**Sent:** 30 September 2013 12:45  
**To:** Planning  
**Subject:** Planning application N6/2013/1769/AD - Premier Inn, Stanborough Road

**Response to Planning application from Hertfordshire County Council (T and CP GDP Order 1995)**

**Proposal**  
Installation of 4.5 totem double sided, free standing structure

Site Plan

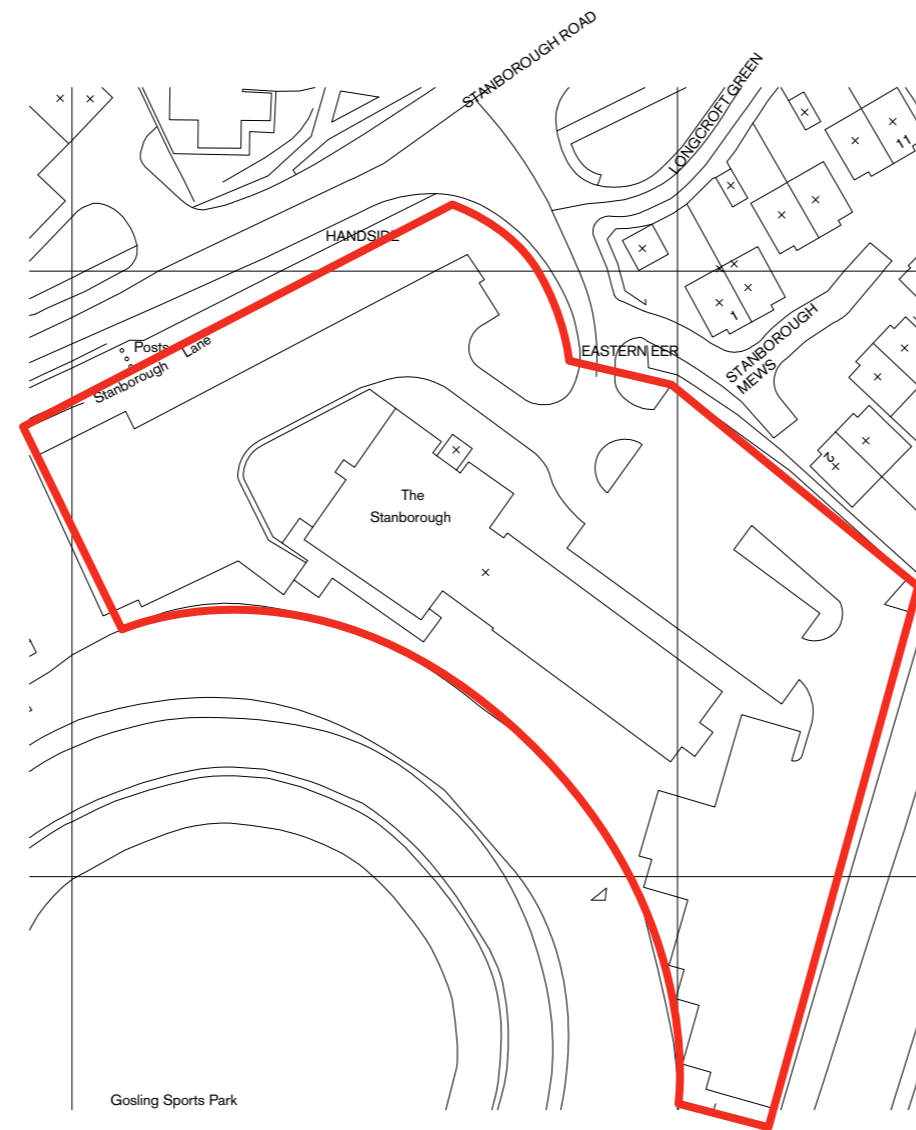
I am advised that the extent of public highway includes most of the verge behind the combined cycleway/footway. Therefore it appears the sign is located within the public highway and such a location would require licensing by the highway authority.

The applicant would be advised to contact the Highway Boundaries & Land Charges team at Hertfordshire County Council, telephone 01992 556181 <http://www.hertsdirect.org/your-council/work/foi/fac/ehwayenq/> for details of the location of the highway boundary.

Totem 4.5m

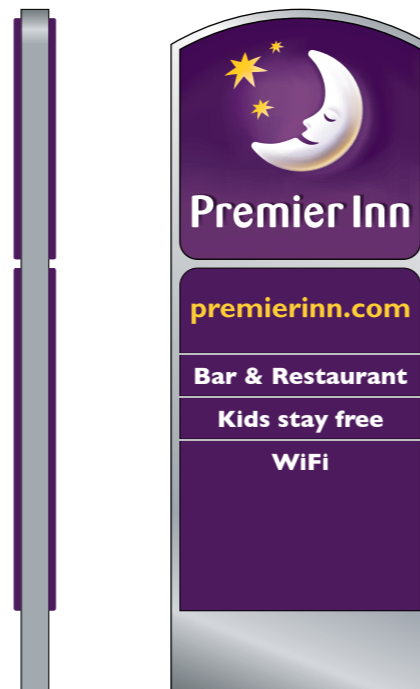
- 1. The intensity of illumination shall be controlled at a level that is within the limit recommended by the Institution of Lighting Professionals in TR5 Brightness of Illuminated Advertisements(2001)

Reason: So that drivers of vehicles along the adjacent highways are not dazzled or distracted, leading to interference to the free and safe flow of traffic along the highway.
